Response to Planning Application

Application ref: Y/155/20/DOC

Description: Approval of details reserved by condition imposed under ref Y/91/17/OUT relating to Condition Nos 7 landscaping & layout, 8 - Arboricultural Method Statement & Tree Protection Plan, 10 - surface water drainage, 13 - Ecological Management & Mitigation Plan, 15 - external lighting and 21 - Travel Plan.

Location: Land at Bilsham Road

7905-L-111 B

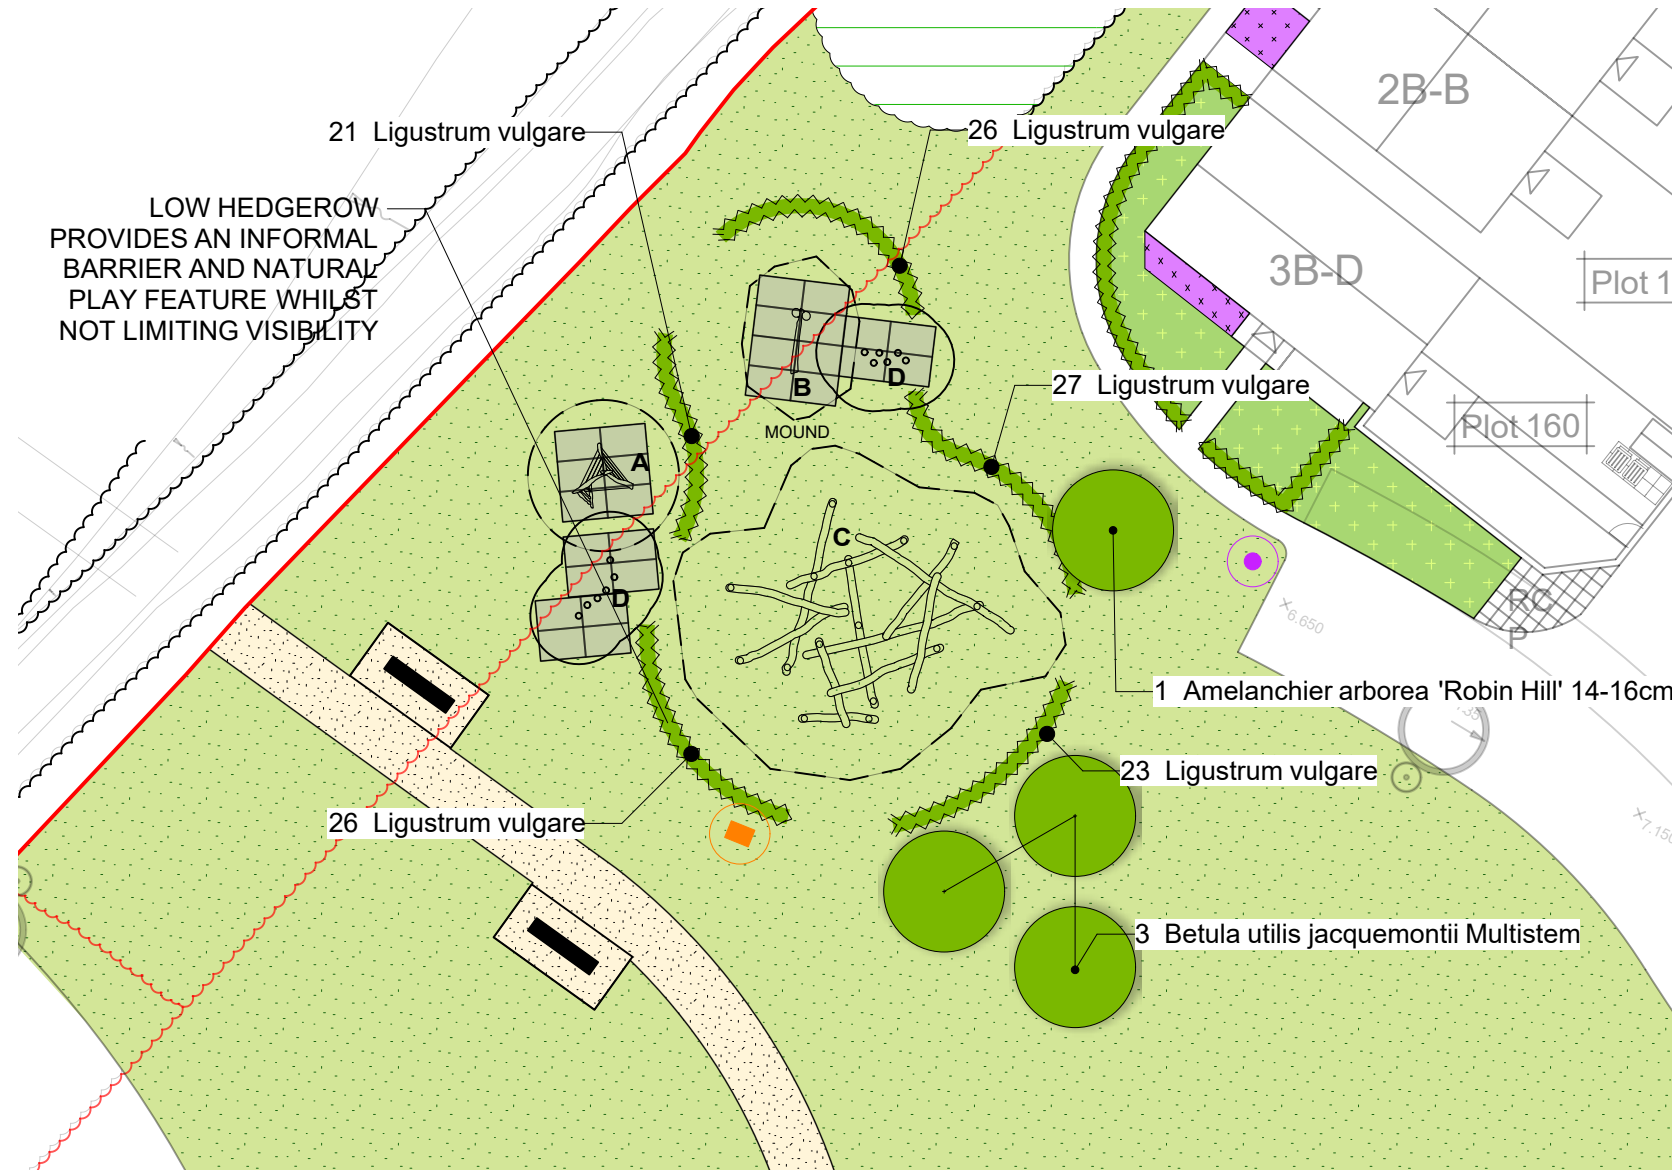
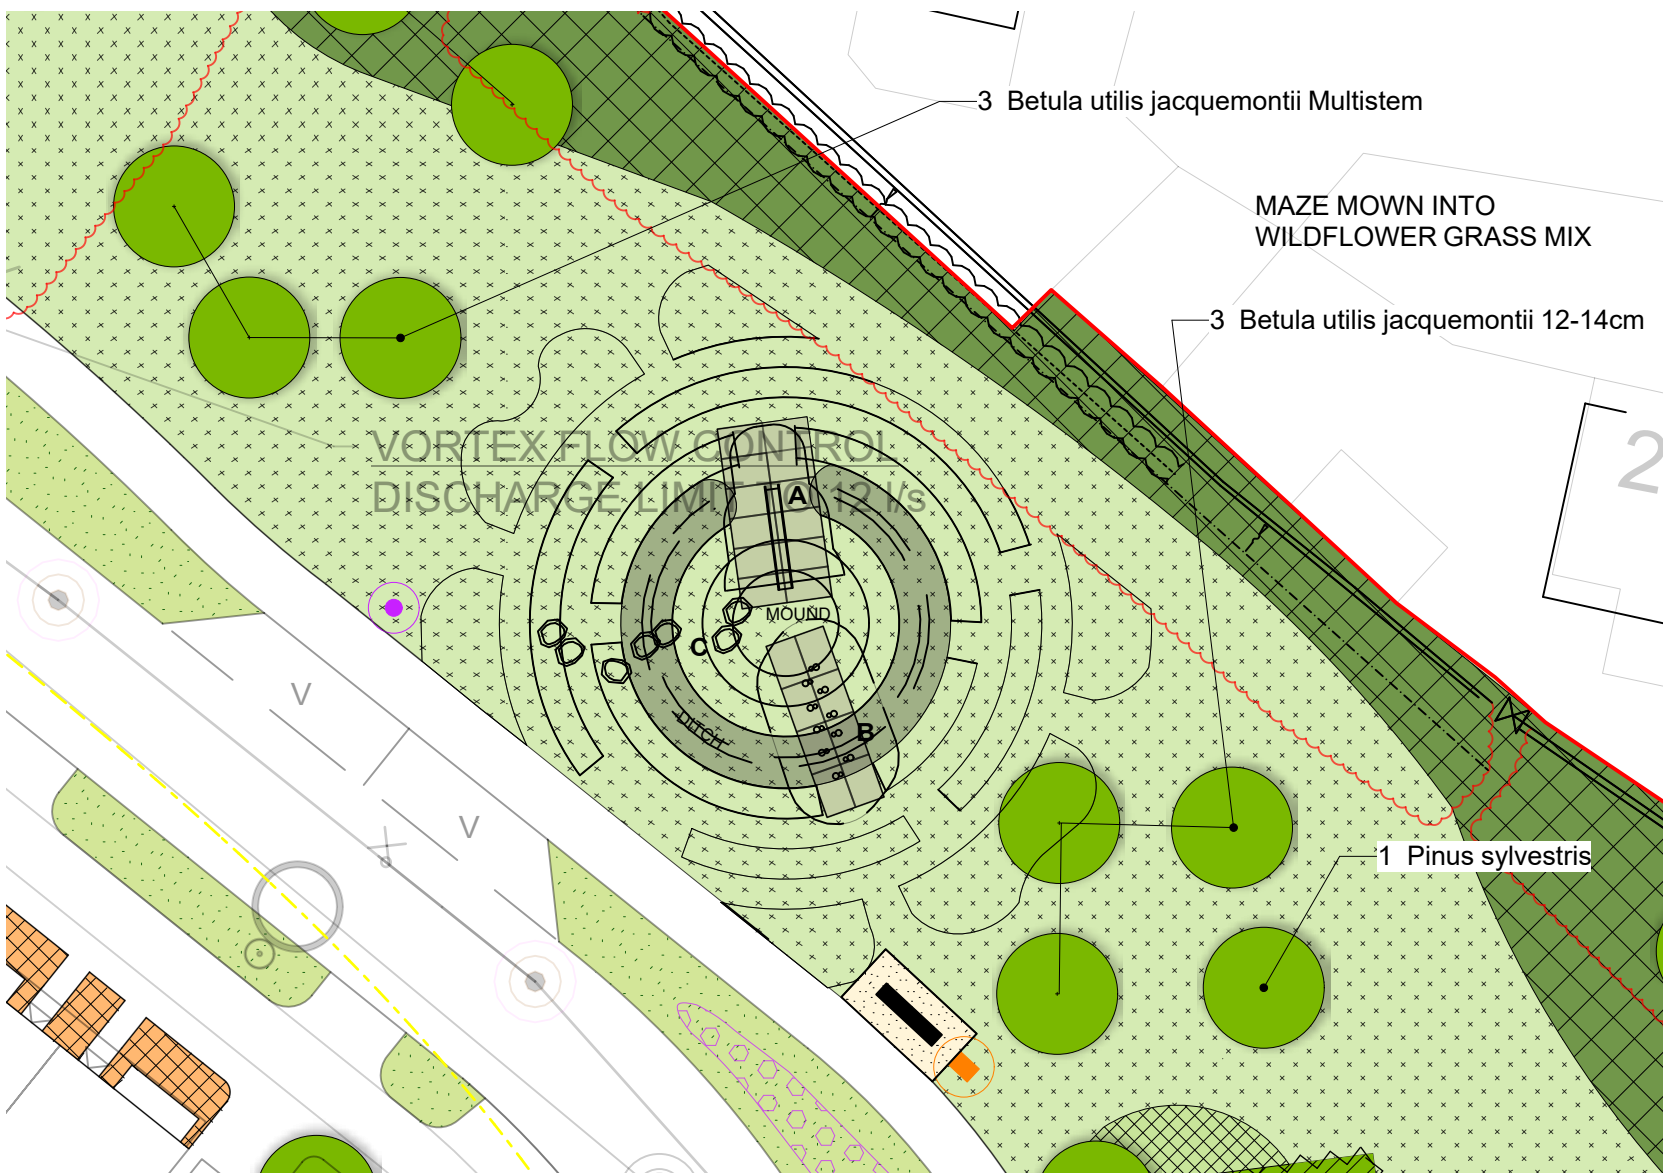
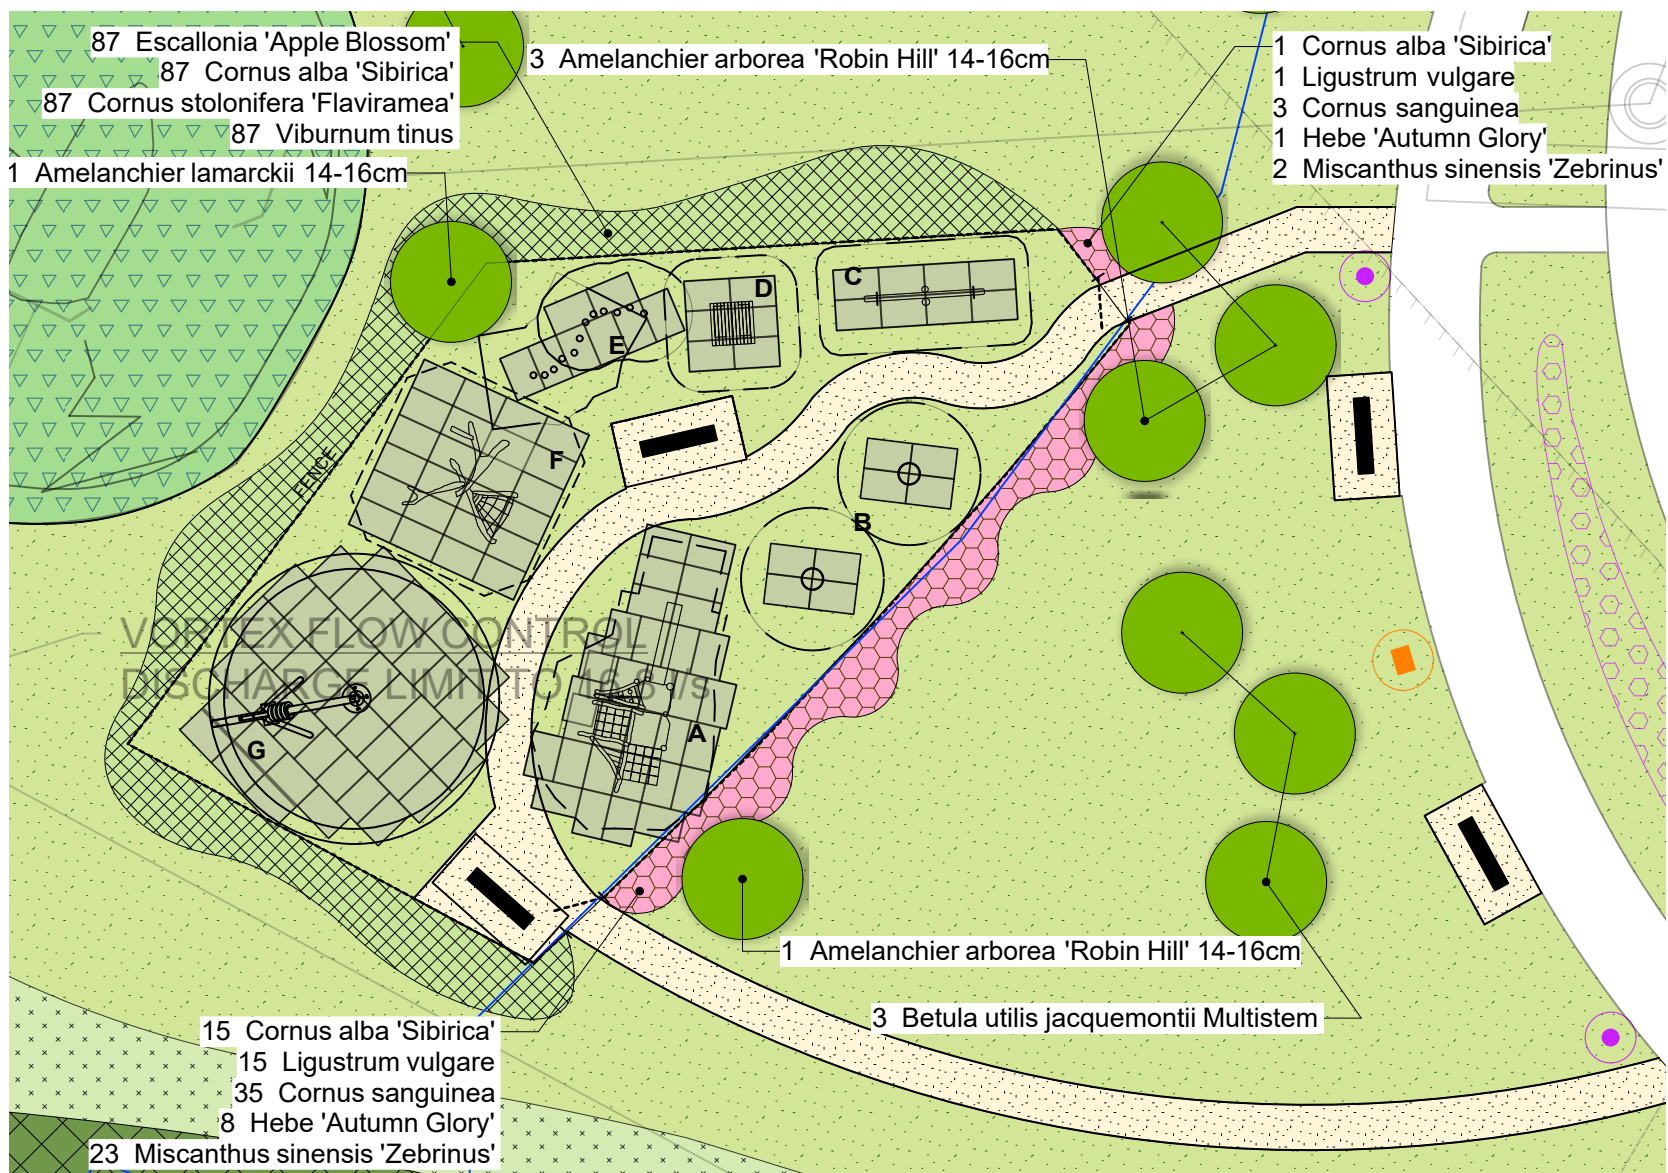
Following submission of play proposals, LAP and LEAP Sheet 11 Play Spaces dwg 7905-L-111 Rev B I can confirm that this proposes detail of children's play which is suitable for location and experiences. Laps have been indicated with both Natural and Semi natural features and formal timber LEAP provision. Connecting pathways have been shown with fencing to provide a secure and dog free play area and soft landscaping. I would **recommend the discharge of Condition 7** Play spaces on this application Y/155/20/DOC imposed under Y/91/17/OUT.
